PLANNING AMENDMENT

H16/0661/99

LAND ADJACENT: WILLESBY HOUSE
ALBION STREET, SPALDING.

ALTERATION TO
EXISTING ACCESS

TITLE
PROPOSED MEANS OF ACCESS TO LAND OFF: ALBION STREET, SPALDING, Lincs.

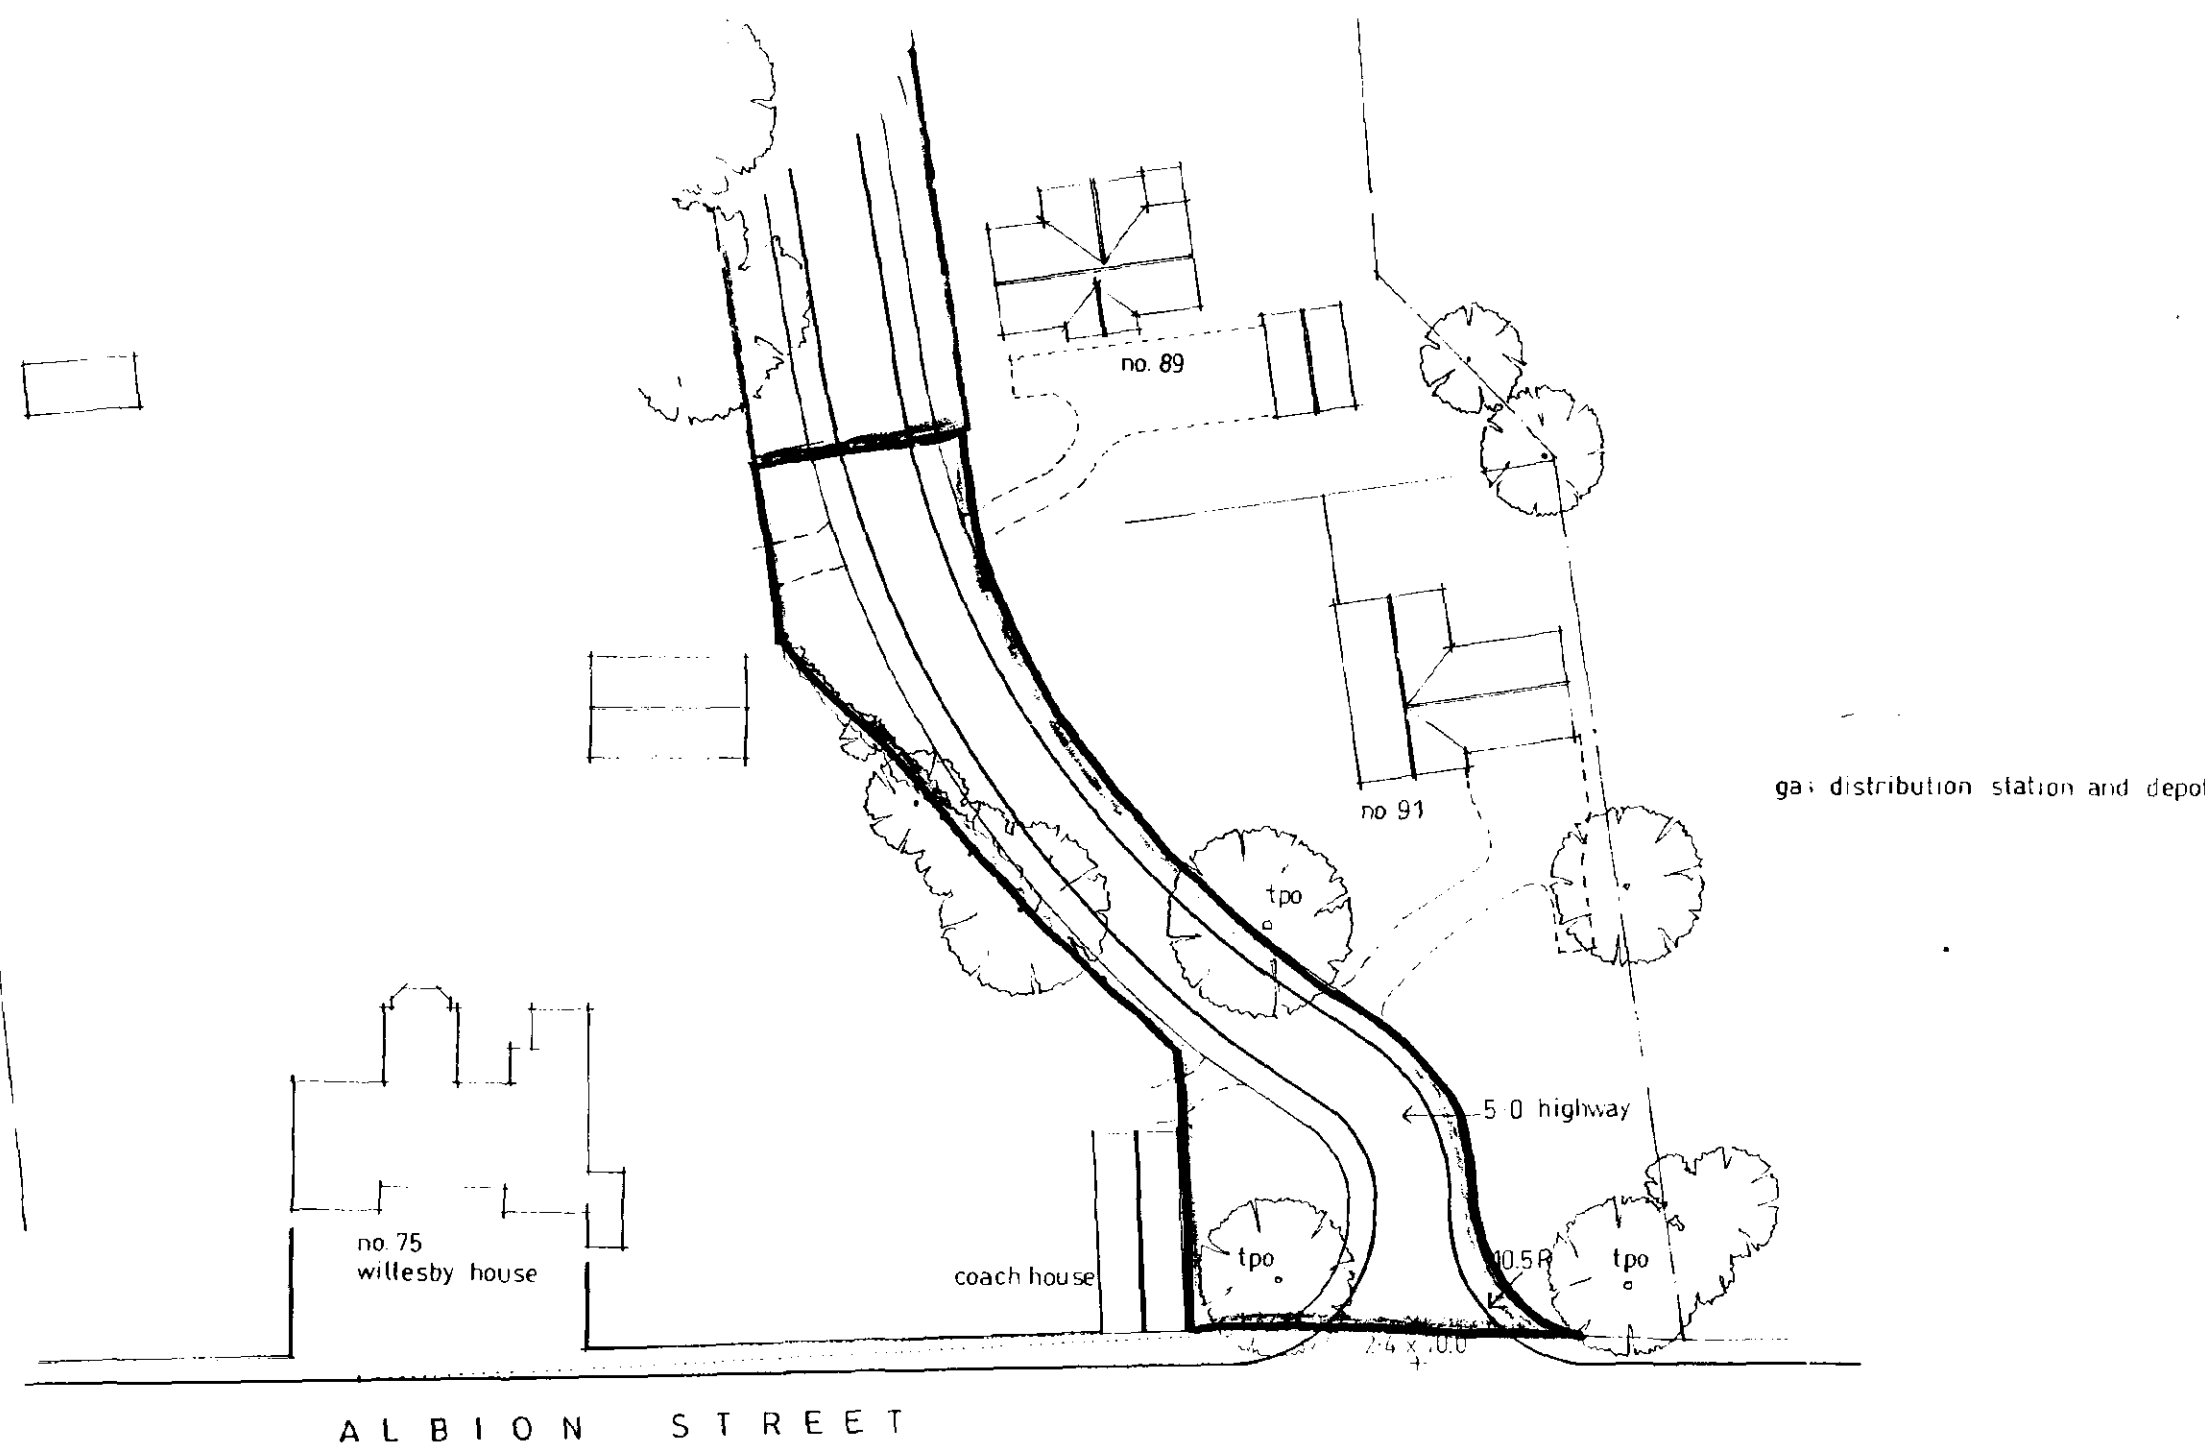
ALTERATION TO
EXISTING ACCESS

COUNTY HIGHWAY
AUTHORITY COMMENTS
- SEE LETTER + PLANS.

TITLE
 PROPOSED MEANS OF ACCESS TO
 LAND OFF:
 ALBION STREET, SPALDING, Lincs.

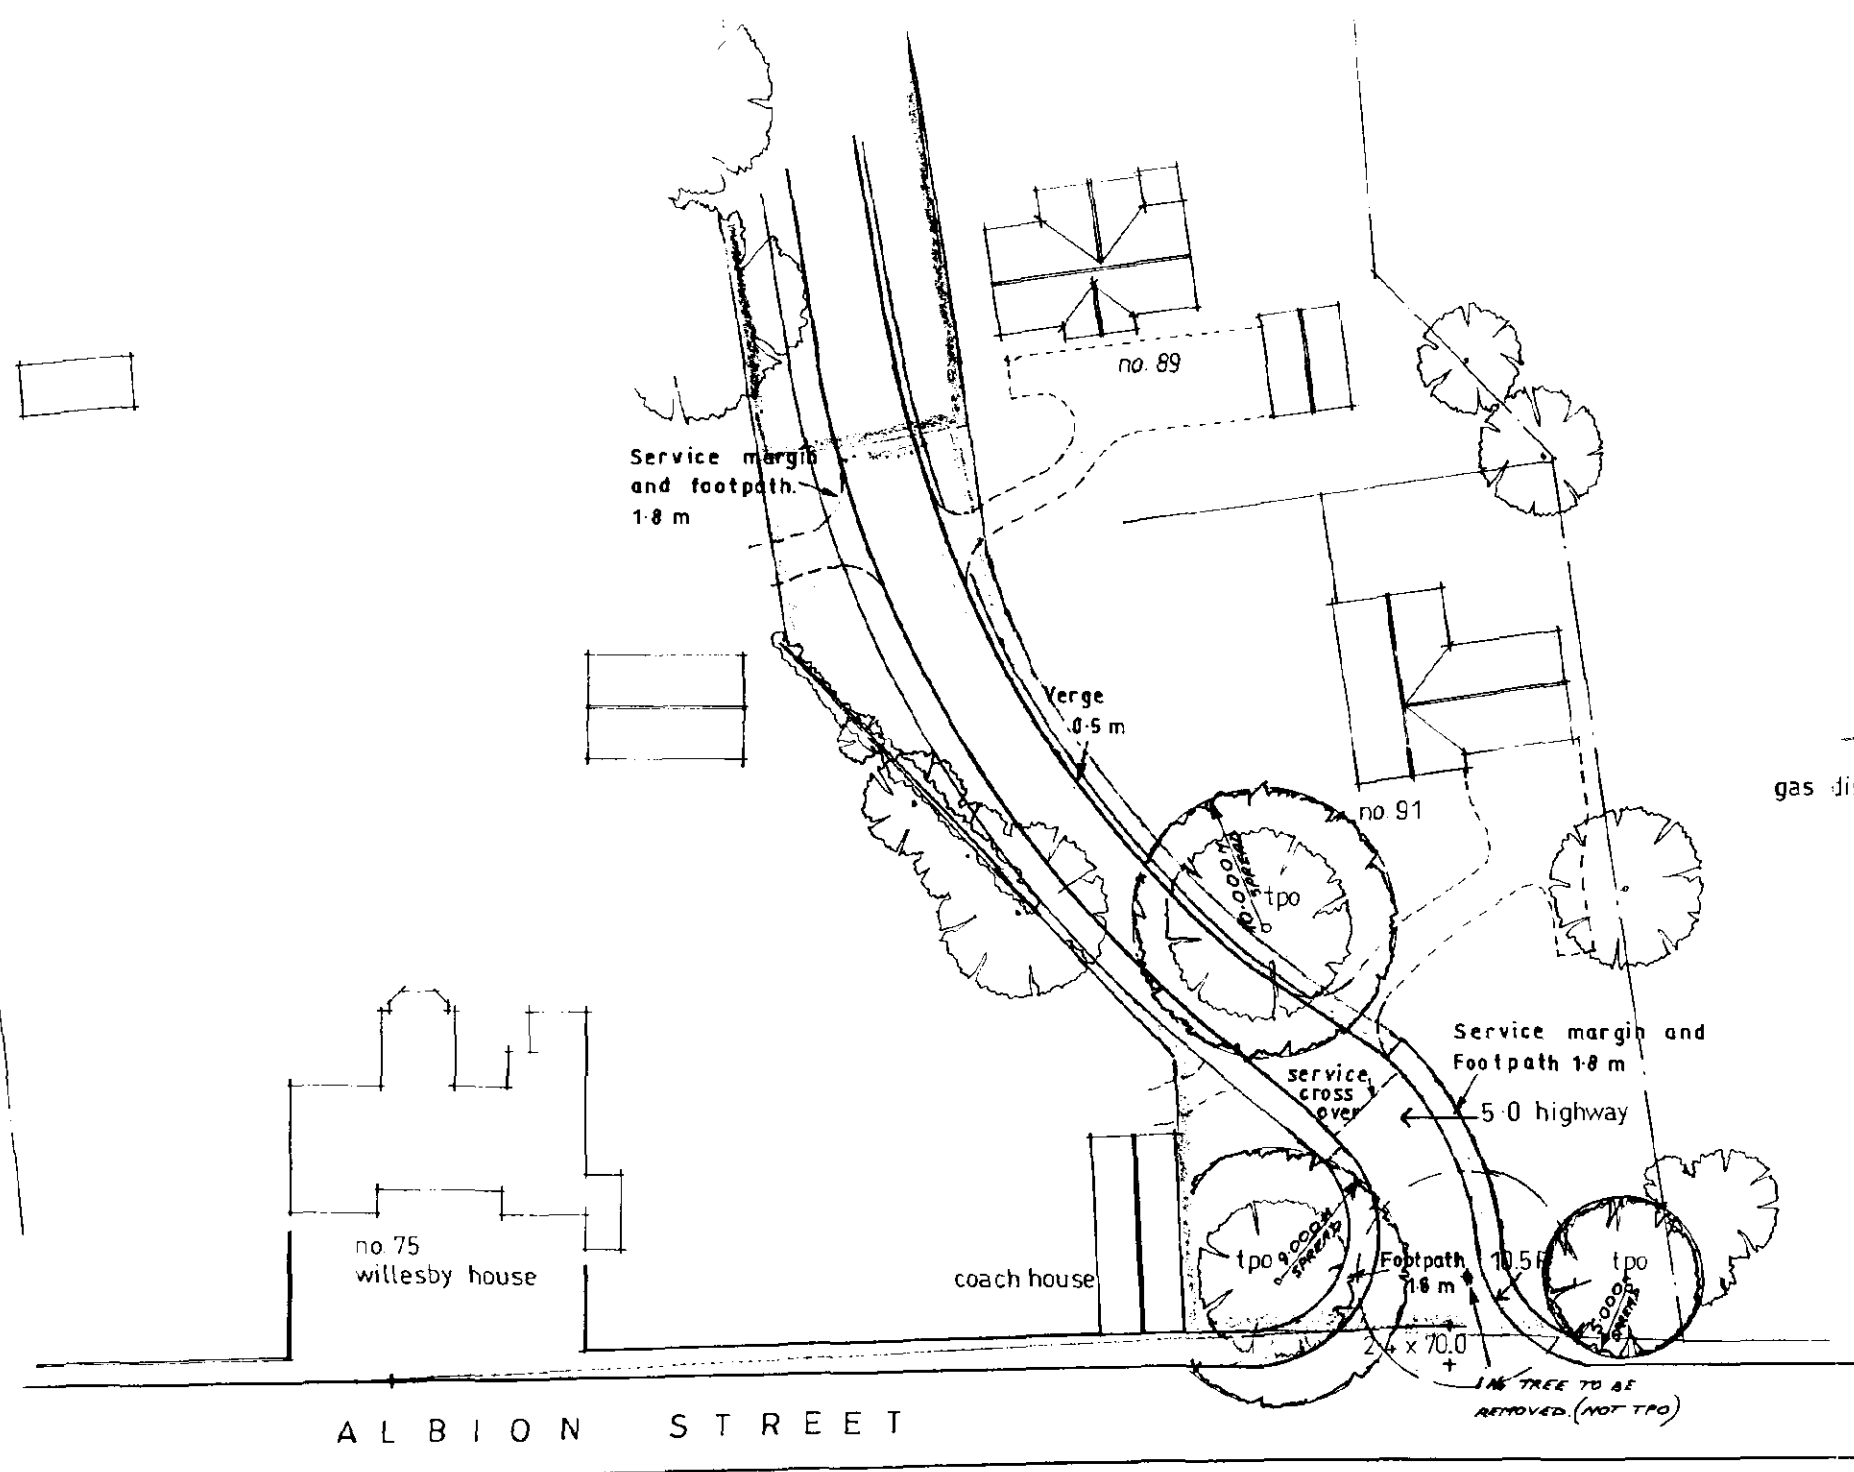
TREE CANOPIES ADDED
ROAD/FOOTPATH/VERGE
ALTERED
